January 14, 2022

**RE: Allaso Vineyards Apartments
Grading and Drainage Plans
Engineer's Stamp Date: 11/19/21
Hydrology File: C20D086**

RE: Allaso Vineyards G&D Plans – Hydrology File C20D086

SHEET TITLE: OVERALL GRADING

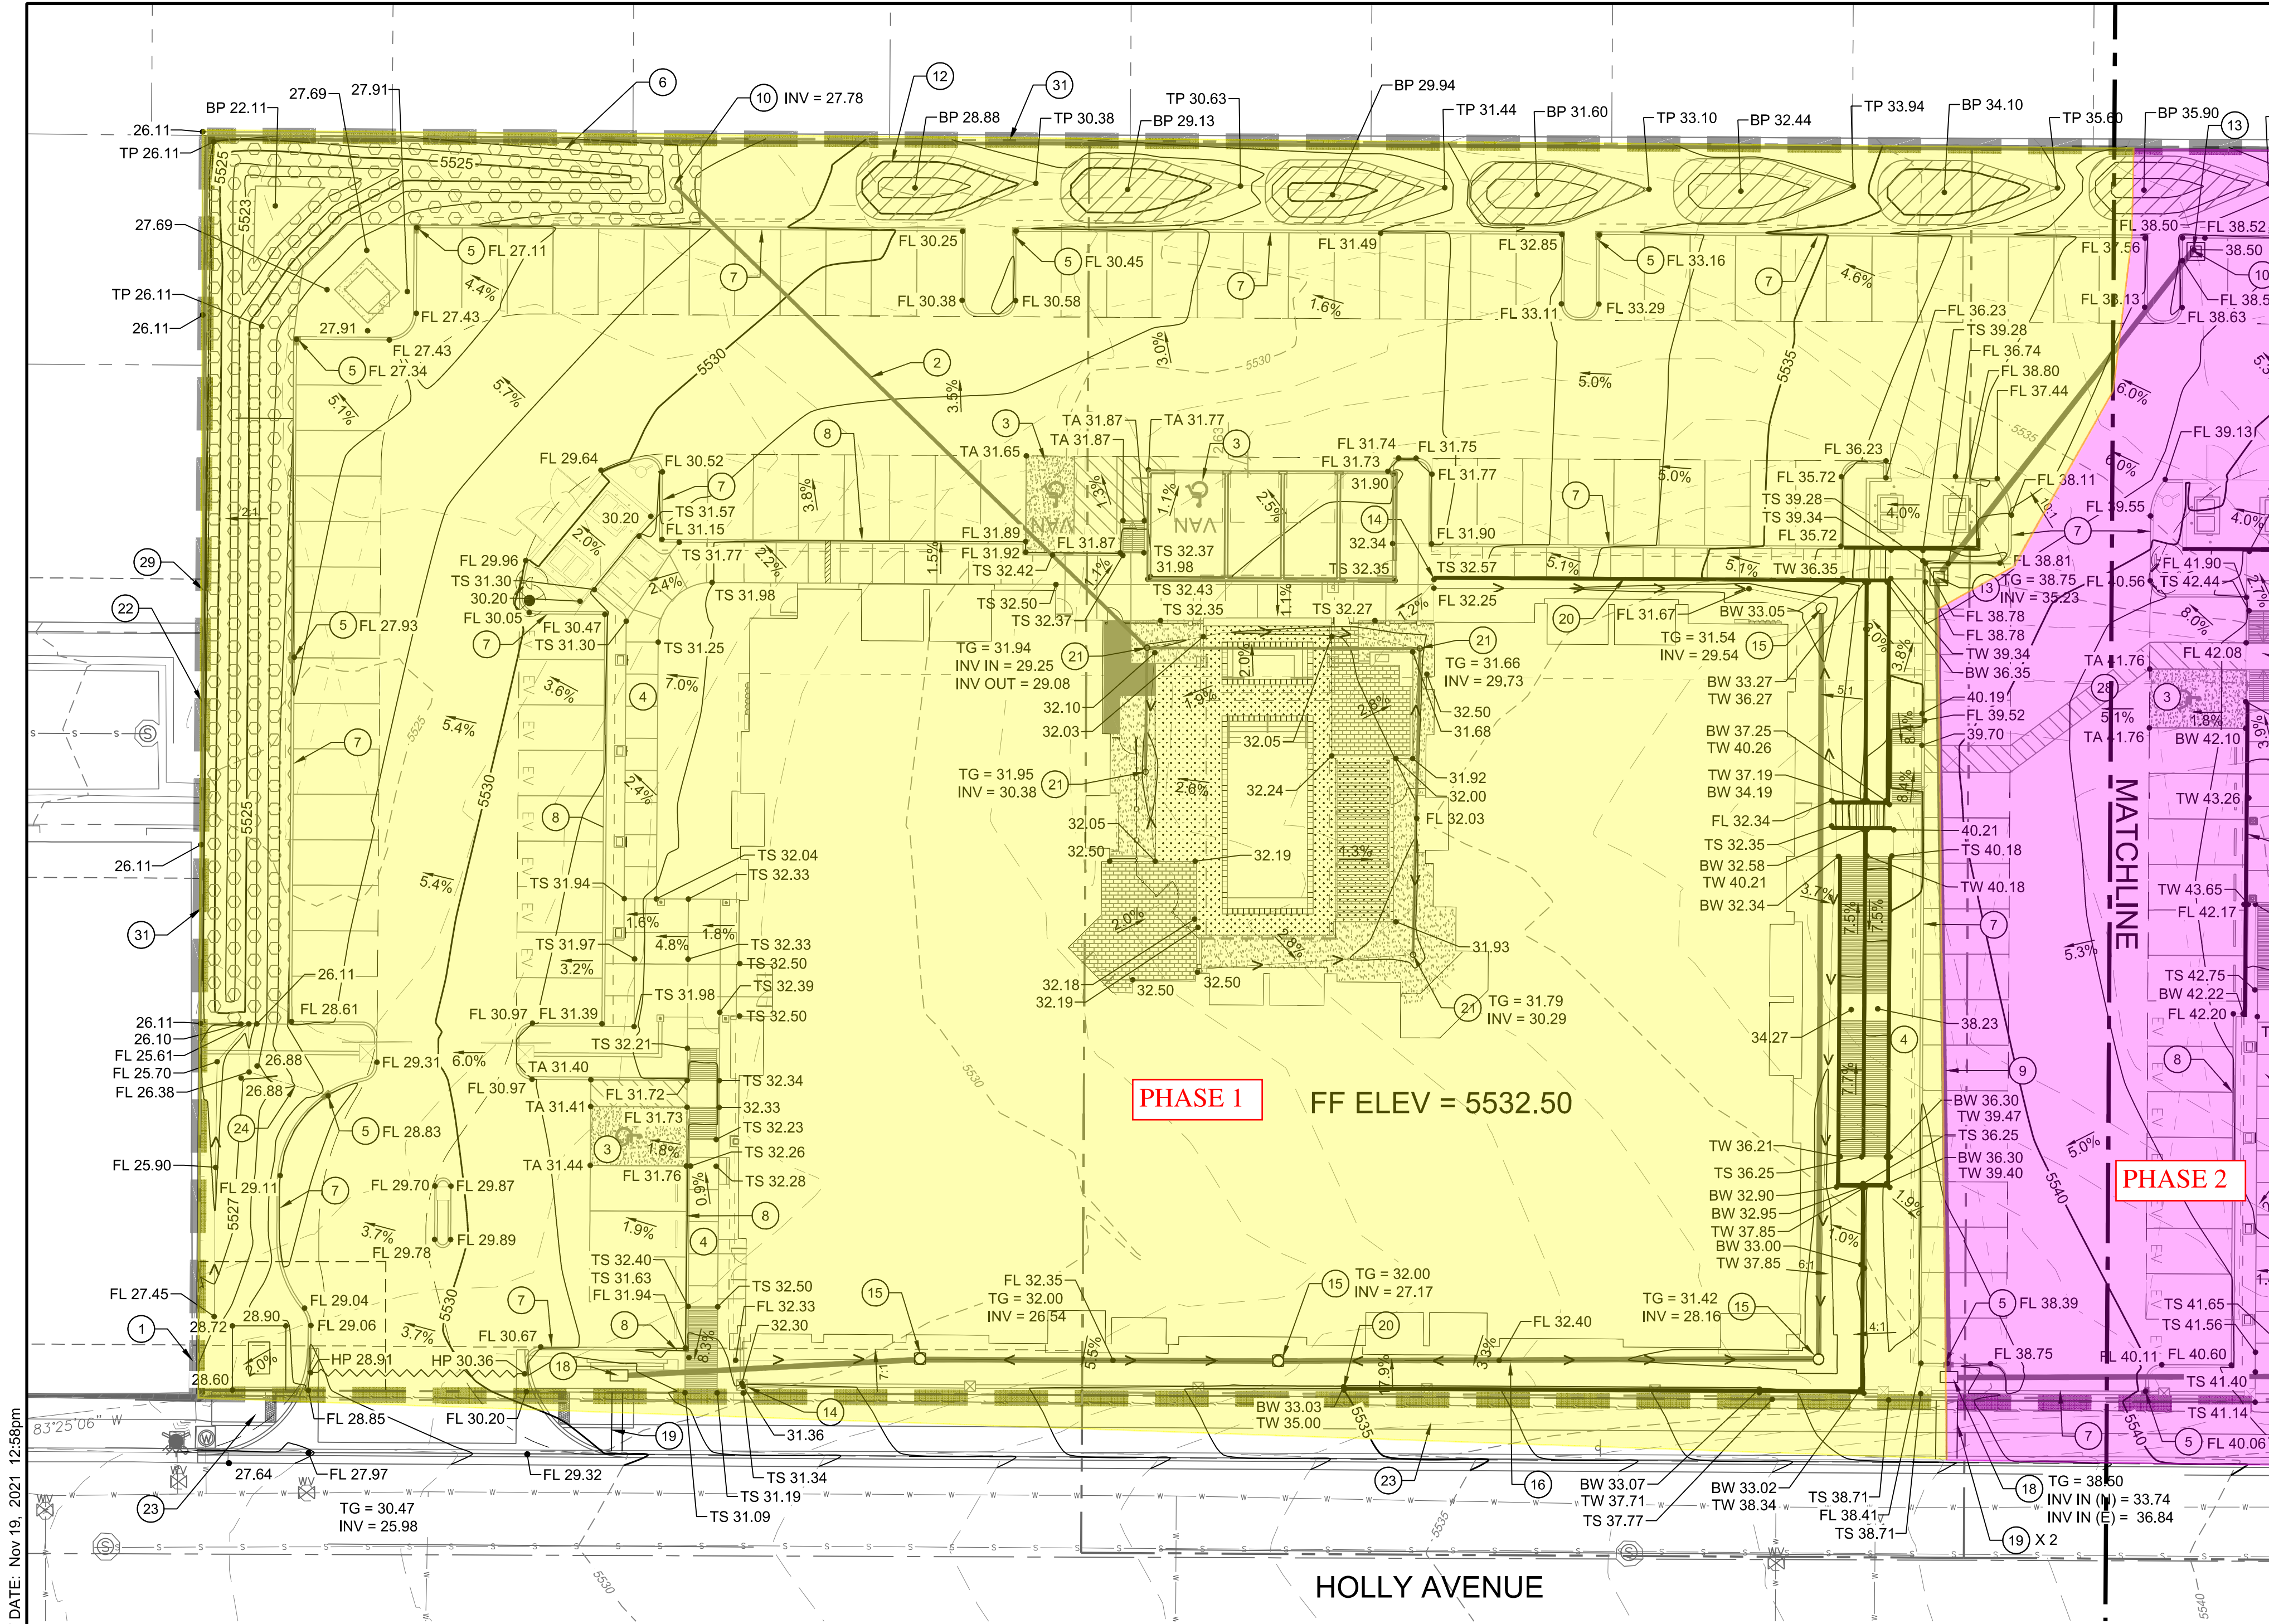
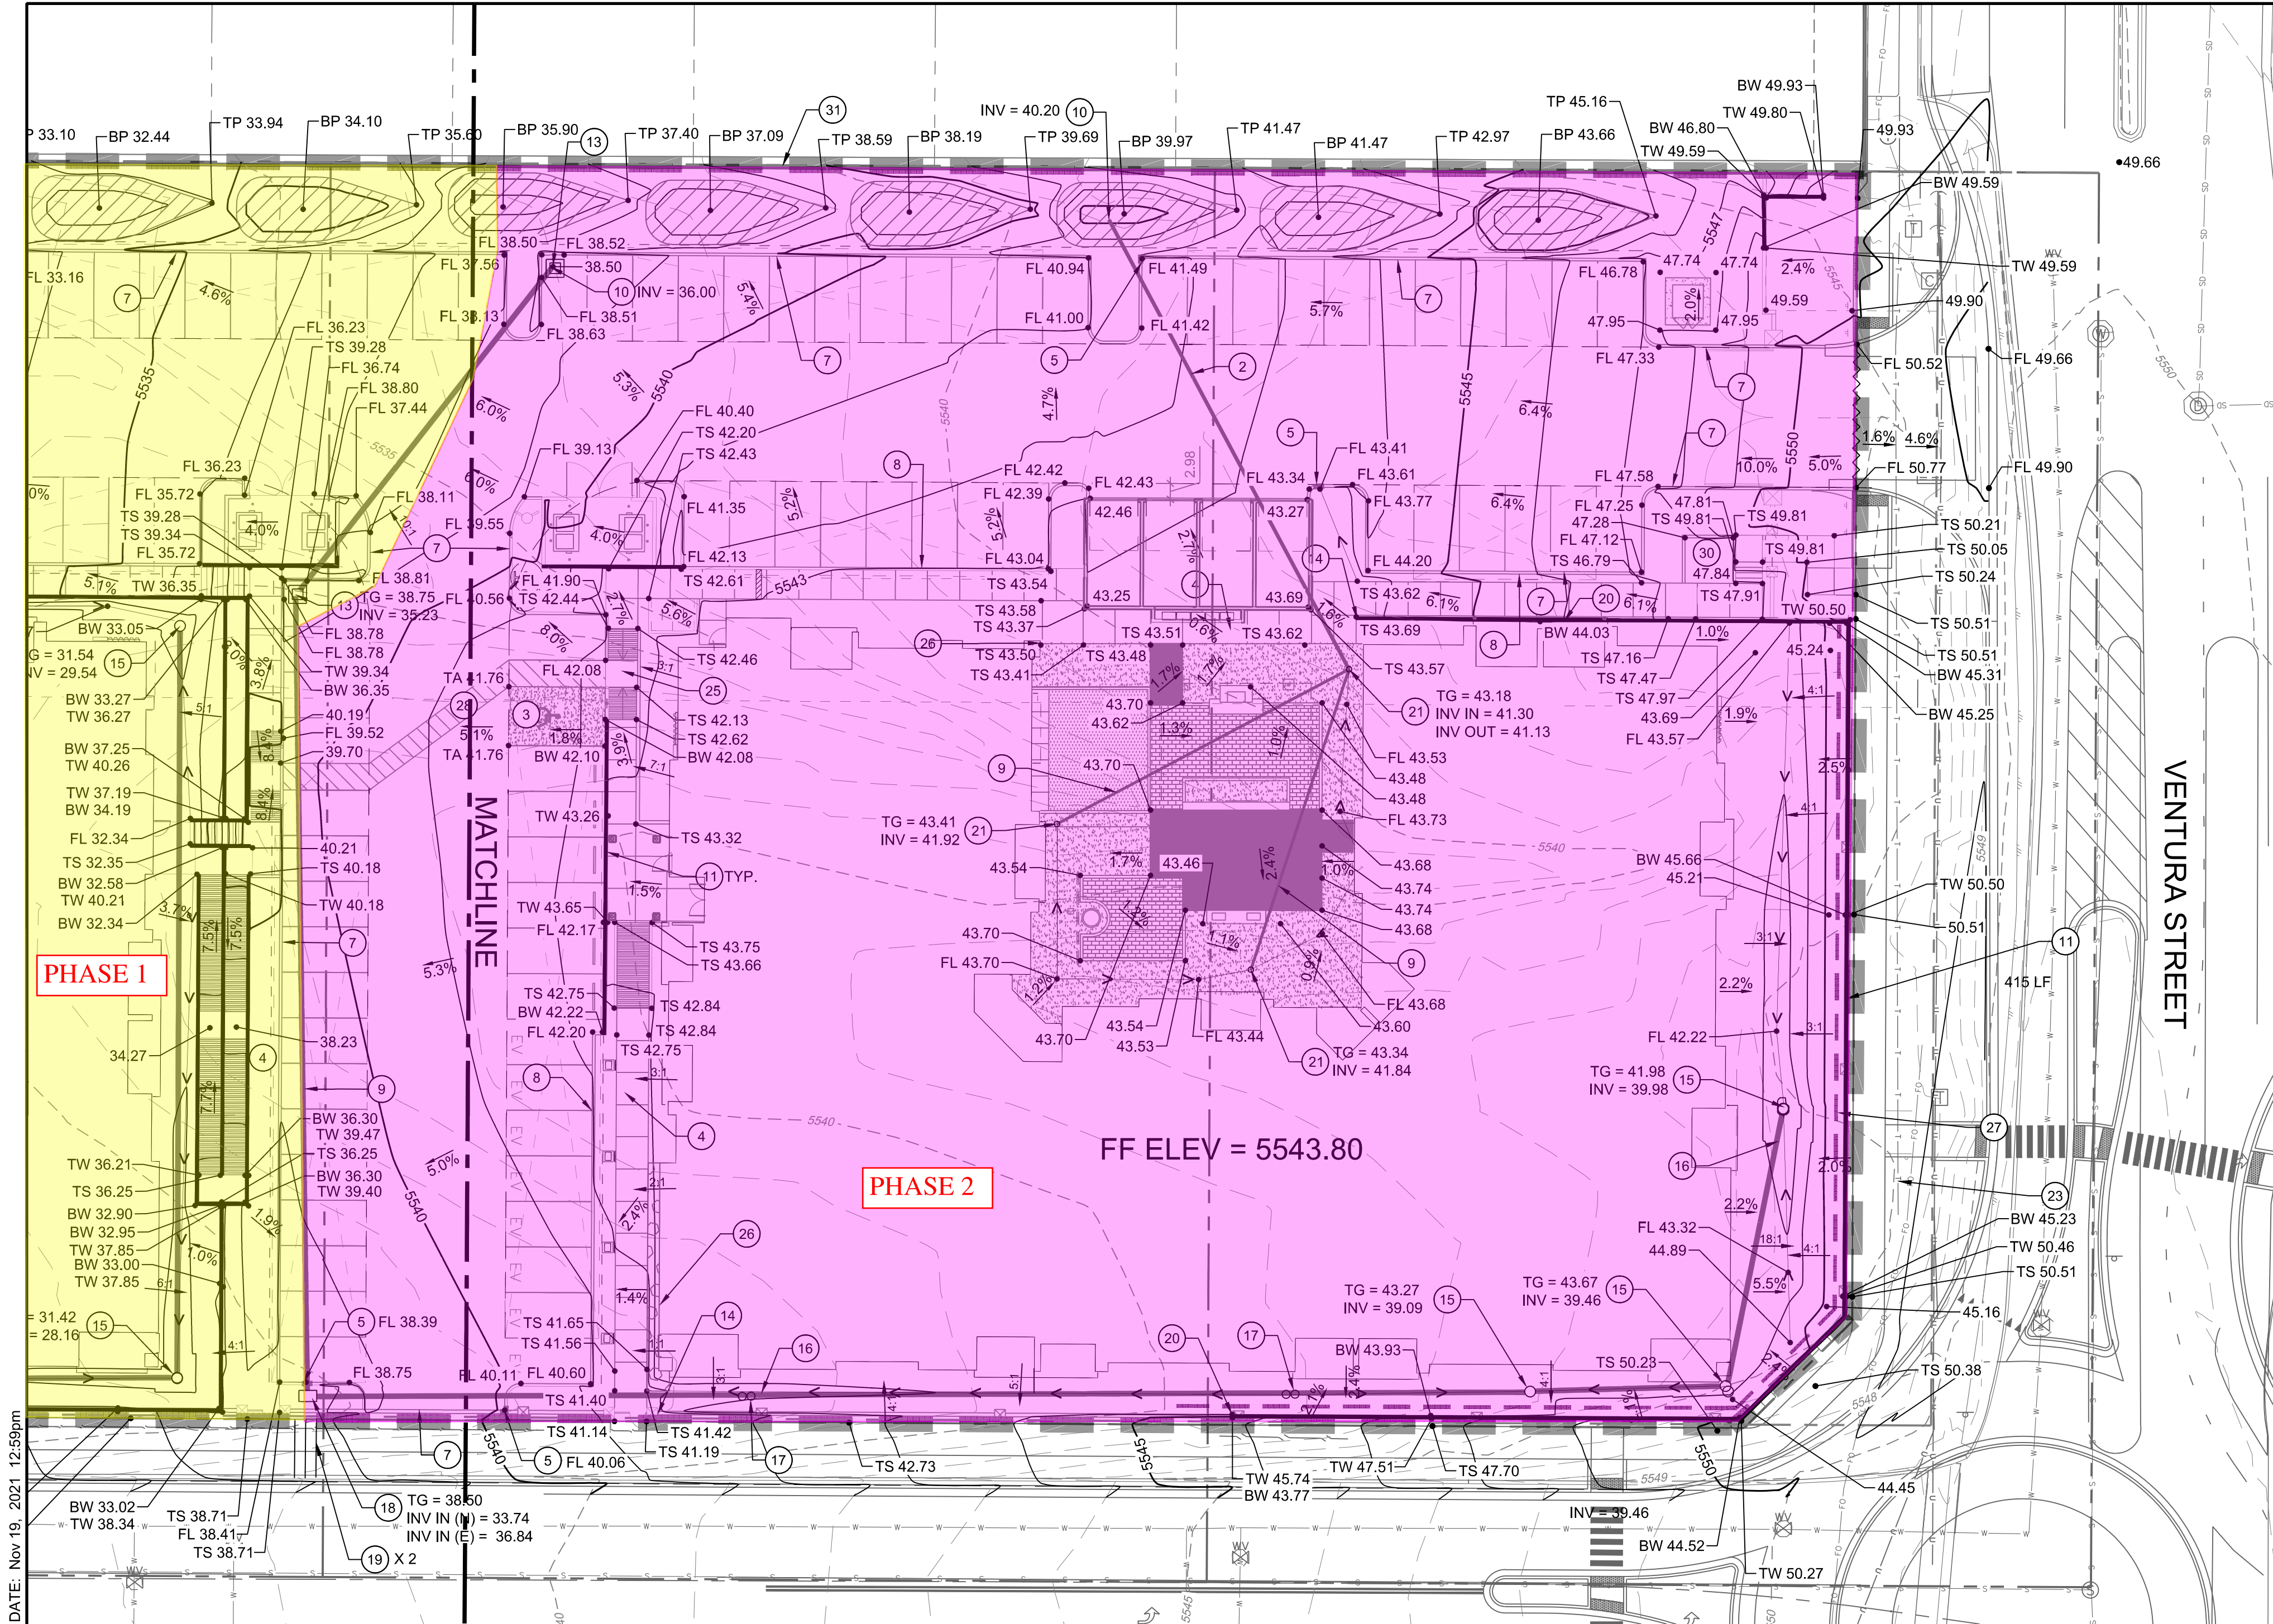
"At two locations there seems to be missing a segment of pipe from on-site type D inlet to curb line?? If this is what you are doing, than a sidewalk culvert is not need but a pipe through curb per COA drawing 2235."

The on-site modified type D inlet is intended to function as a french drain and infiltrate stormwater. When the water surface in the inlet exceeds the inlet's grate elevation, then the water will spill through sidewalk culverts into Holly Avenue. The flows have been calculated such that the stormwater discharged over these grates will not exceed the parameters as outlined in the drainage plan.
